A46 Newark Bypass

Scheme Number: TR010065

Statement of Common Ground with Nottinghamshire County Council

**Statement of Common Ground with
Nottinghamshire County Council**

KEY:

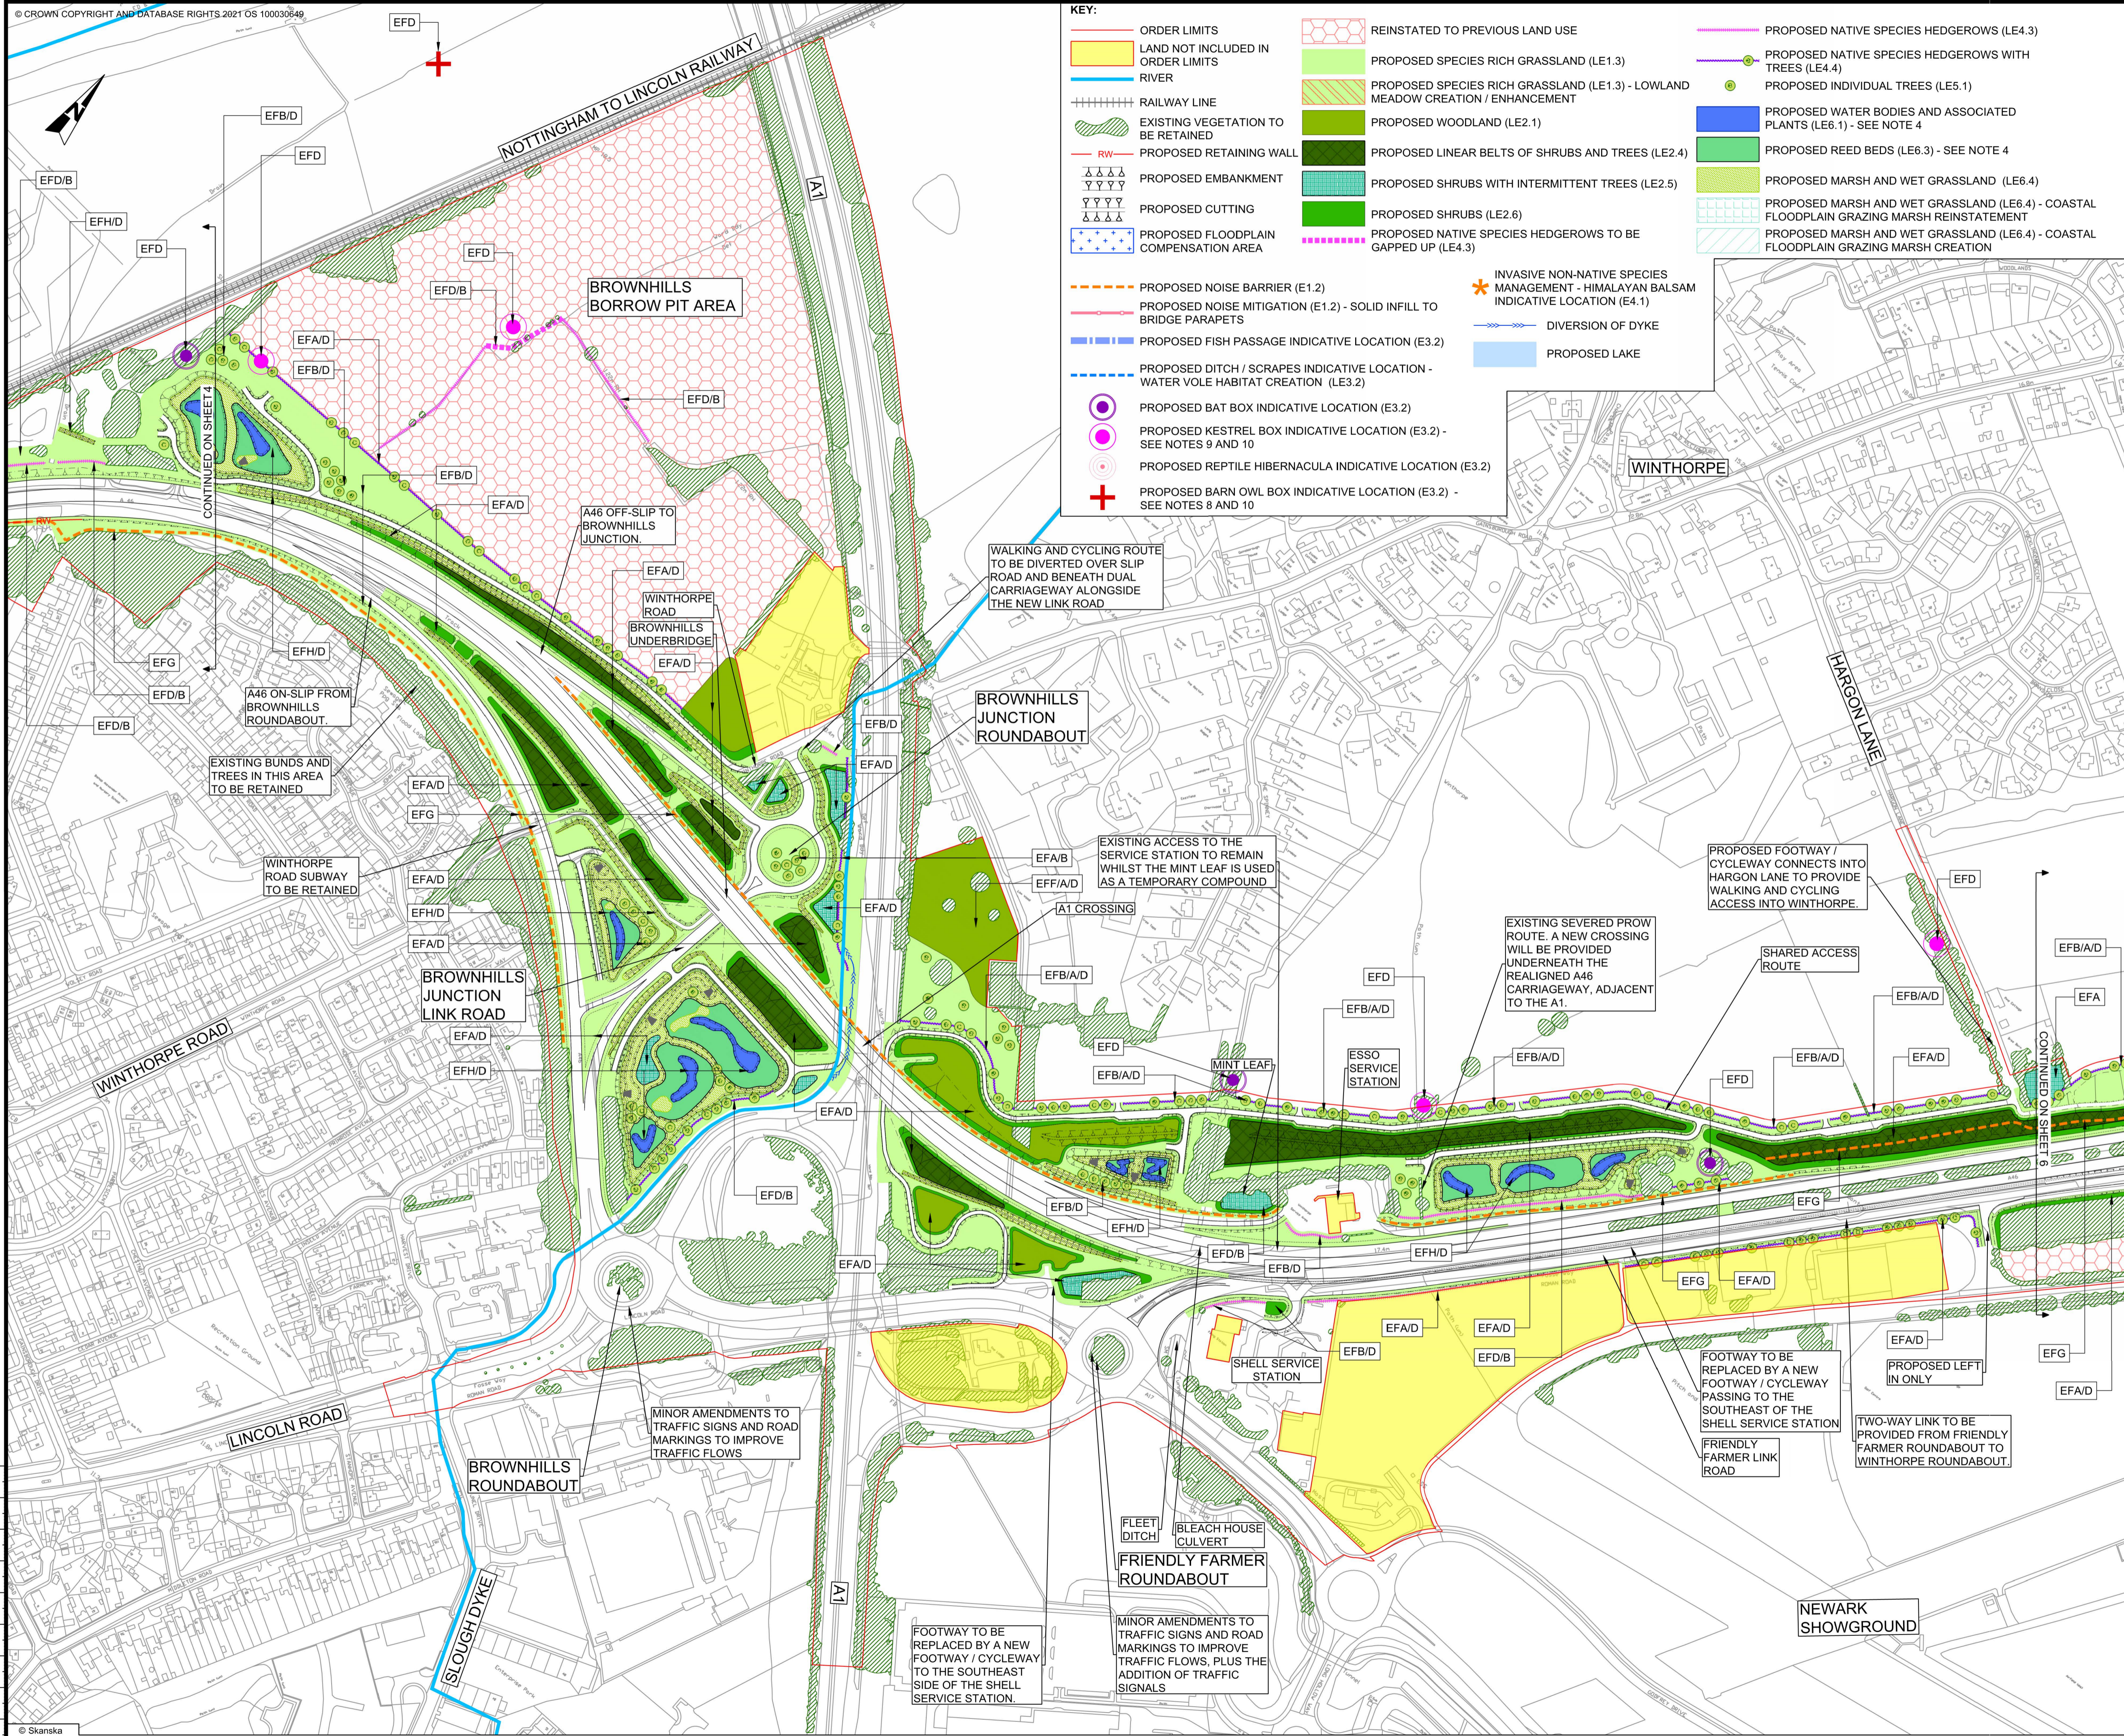
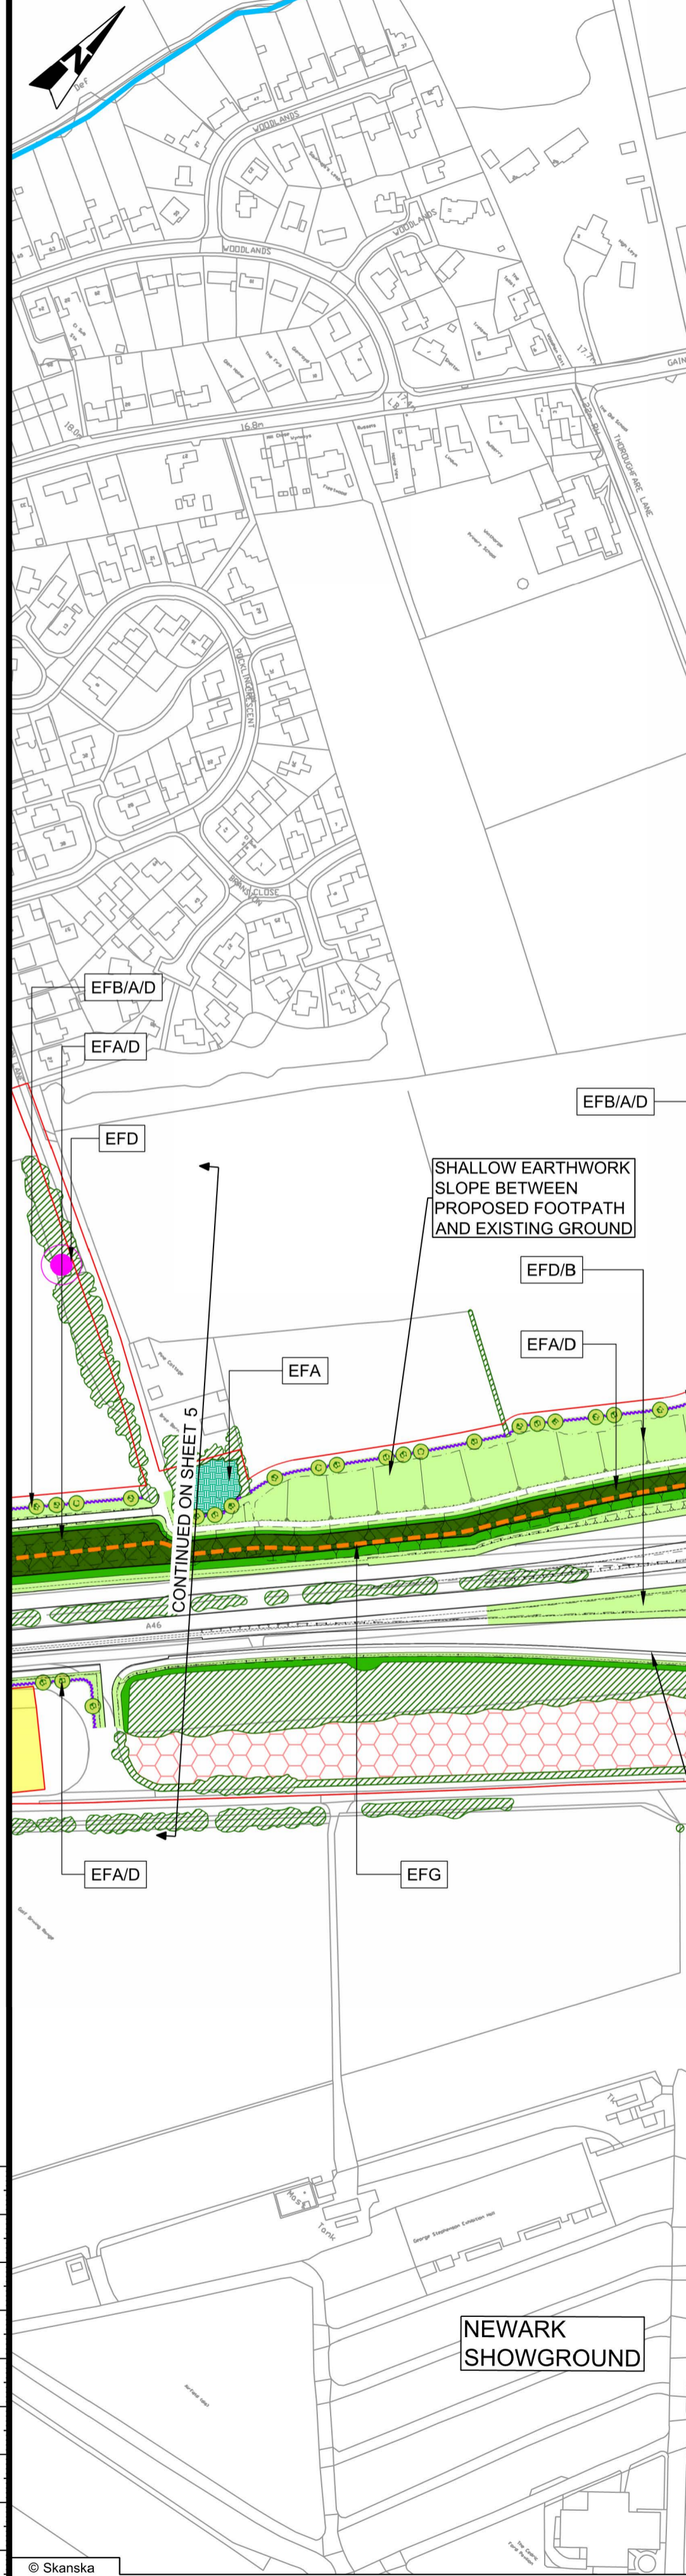
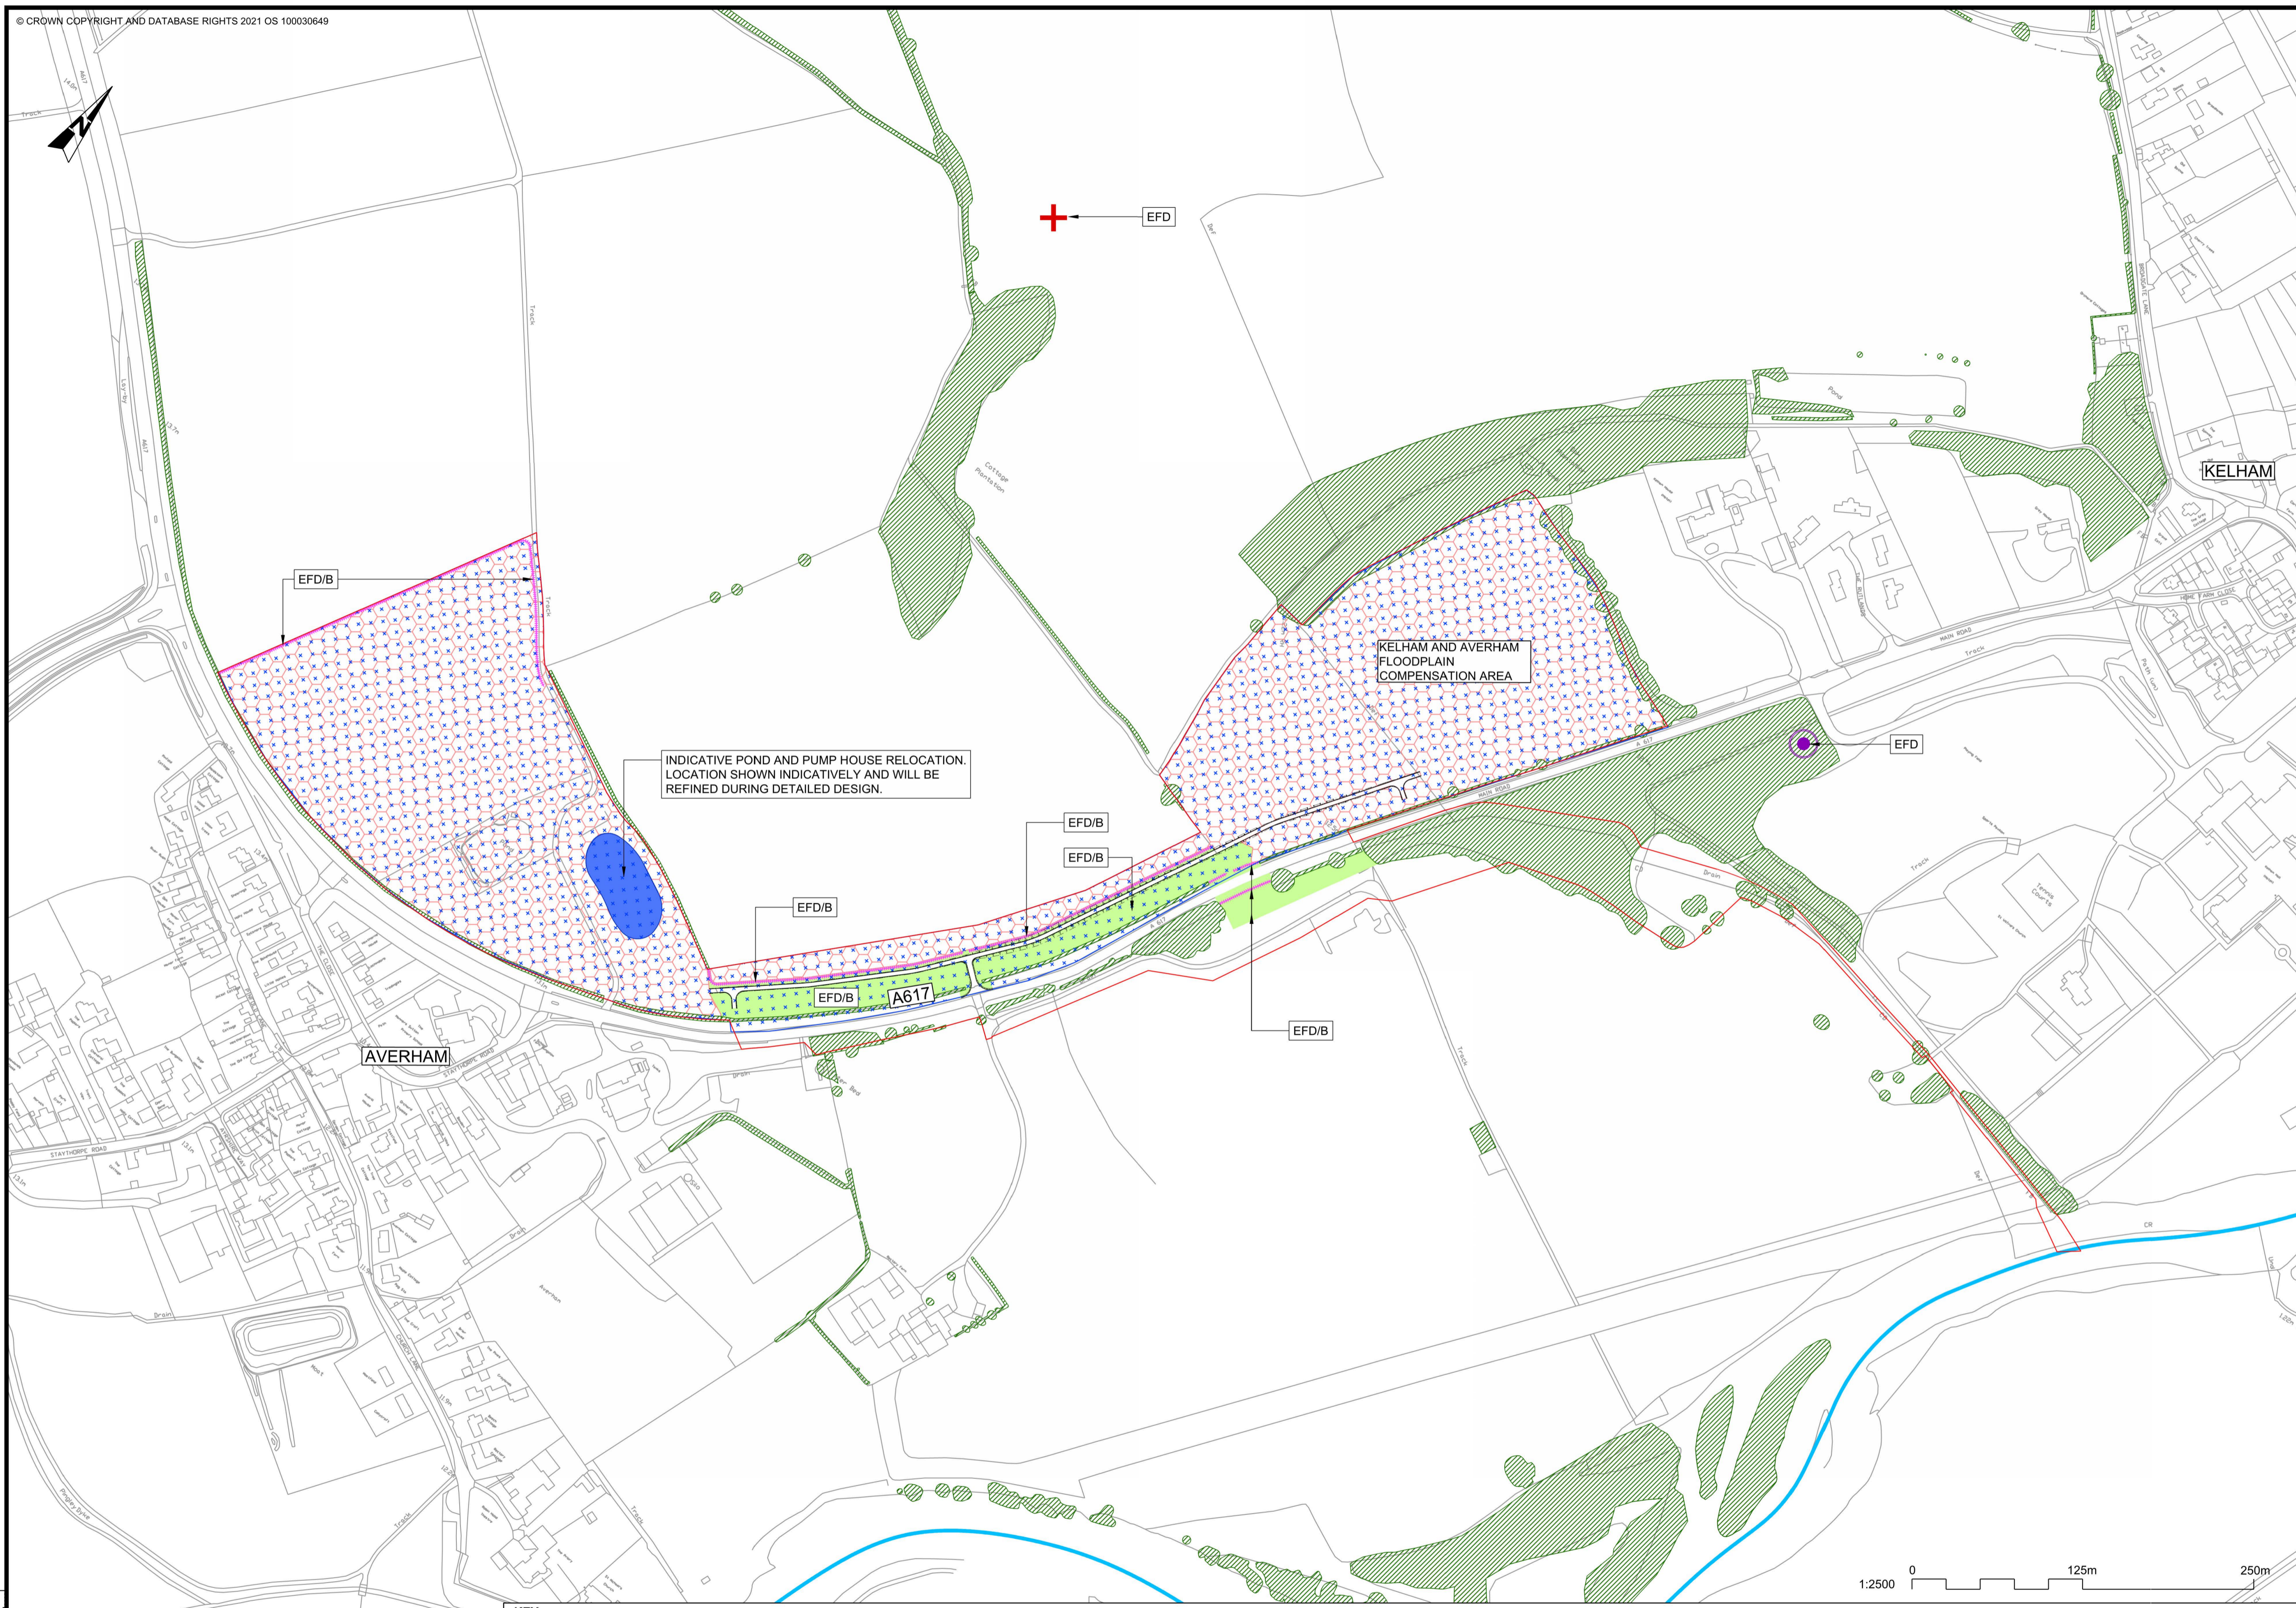
21.	Ecology (biodiversity)	6.2 Environmental Statement - Figure 2.3 Environmental Masterplan [AS-026] 6.2 Environmental Statement - Figure 8.4 - Planting for Loss of Local Wildlife Site Habitats [AS-045] 6.3 Environmental Statement - Appendix 8.1 Extended Phase 1 Habitat Technical Report Part 1 [APP-145] & Part 2 [APP-146] 6.1 Environmental Statement - Chapter 8 Biodiversity [APP052] 6.3 Environmental Statement - Appendix 8.2 National Vegetation Classification Technical Report [APP-147].	<p>Attenuation pond locations</p> <p>The Scheme will inevitably lead to the loss of Local Wildlife Site habitat contained within the Great North Road Grasslands LWS 2/778 at the Cattle Market junction. Unfortunately, these losses are compounded by the location of attenuation basins within two parts of this LWS. Given that there appear to be other places within the DOL boundary in the immediate vicinity of the junction which are not covered by LWS designation, the attenuation basins should be moved to minimise impacts on designated sites caused by the scheme and correctly apply the mitigation hierarchy (i.e. by avoiding impacts in the first instance)</p> <p>Relating to the Environmental Information report</p> <p>Para. 9.5.9</p> <p>National Vegetation Classification (NVC) surveys should also be undertaken of affected LWS grasslands (recognising that some may have declined in quality and therefore no longer be 'good quality semi-improved grassland', but it will be important that this can be evidenced).</p>	<p>Re-locating the basins outside of the Local Wildlife Site would require direct run-off against the natural fall of the land as well as the highway, which in turn would lead to piped runs at unrealistic depths or swales having to be raised higher to allow flows to be conveyed towards the basin. The basins are therefore still proposed within the Local Wildlife Site but have been developed to ensure nature-based solutions are maximised wherever practicable. A compensation package has been designed to provide the equivalent habitat type to that lost within each Local Wildlife Site, details of which can be found in 6.2 Environmental Statement - Figure 2.3 Environmental Masterplan [AS-026] and 6.2 Environmental Statement - Figure 8.4 - Planting for Loss of Local Wildlife Site Habitats [AS-045].</p> <p>Habitats within the Scheme study area were initially identified, classified and mapped in accordance with the Joint Nature Conservation Committee's <i>Handbook for Phase 1 Habitat Survey</i>. The habitats identified are detailed within Appendix E of 6.3 Environmental Statement - Appendix 8.1 Extended Phase 1 Habitat Technical Report Part 1 [APP-145] & Part 2 [APP-146] and 6.1 Environmental Statement - Chapter 8 Biodiversity [APP052]. Habitats identified during the Phase 1 habitat survey as potential Priority Habitats and any Local Wildlife Site habitats (including grasslands) were subsequently subject to a National Vegetation Classification survey to confirm the habitat classification against the Local Wildlife Site citation 6.3 Environmental Statement - Appendix 8.2 National Vegetation Classification Technical Report [APP-147]. The following communities were found to be present within the survey area; MG1, MG4, MG5, OV26, W8 and W10. Where appropriate, all accessible habitats were subject to habitat condition assessments with reference to the <i>Biodiversity Metric 3.1 Technical Supplement (Panks et al., 2022)</i>.</p> <p>A precautionary approach has been taken to assigning condition for baseline habitats where condition was not assessed as part of the Phase 1 Habitat survey / where no National Vegetation Classification surveys were undertaken, due to access constraints. In these cases, the baseline condition was precautionarily assessed as good. This is also applicable to habitats located within all Local Wildlife Sites potentially impacted by the Scheme.</p>	Under Discussion	18/10/2024

26.		6.2 Environmental Statement - Figure 2.3 Environmental Masterplan [AS-026].	<p>New floodplain habitat</p> <p>The borrow pit and floodplain compensation areas provide an opportunity to create new floodplain habitat on at least some of the land identified. With careful design, wet grassland (to include ditches, pools and scrapes) can be created, providing habitat for things like breeding waders and wintering wildfowl, whilst allowing ongoing farming practices through grazing. Marsh and swamp, reedbed and ponds should also be considered. As part of the design, public access should be provided, where possible, in such a way that does not impinge on farming activities or that would lead to disturbance of wildlife.</p>	<p>Farndon East and Farndon West are proposed as floodplain compensation area sites. Farndon West would also provide essential mitigation in the form of habitat creation, enabling multiple benefits. The design principles for these areas are to create highly distinctive habitats that complement local biodiversity whilst also being appropriate to floodplain conditions and allow high confidence in successful establishment. The environmental design for these areas including the essential mitigation measures can be seen on 6.2 Environmental Statement - Figure 2.3 Environmental Masterplan [AS-026].</p> <p>The main habitats within Farndon West floodplain compensation area include a network of ponds and reedbeds surrounded by marsh and wet grassland with individual trees, as well as an area of floodplain grazing marsh, together with fringe areas of species-rich grassland and planting of individual trees. Habitat in the form of marsh and wet grassland around the edges of the lake in Farndon East floodplain compensation area would also be provided. For these areas in particular, public access is not provided in order to maximise the biodiversity value of the areas (reducing stresses presented by public use, such as dog walking) and also to reduce health and safety risks posed by ponds (former borrow pits which would hold standing water).</p>	Under Discussion	18/10/2024
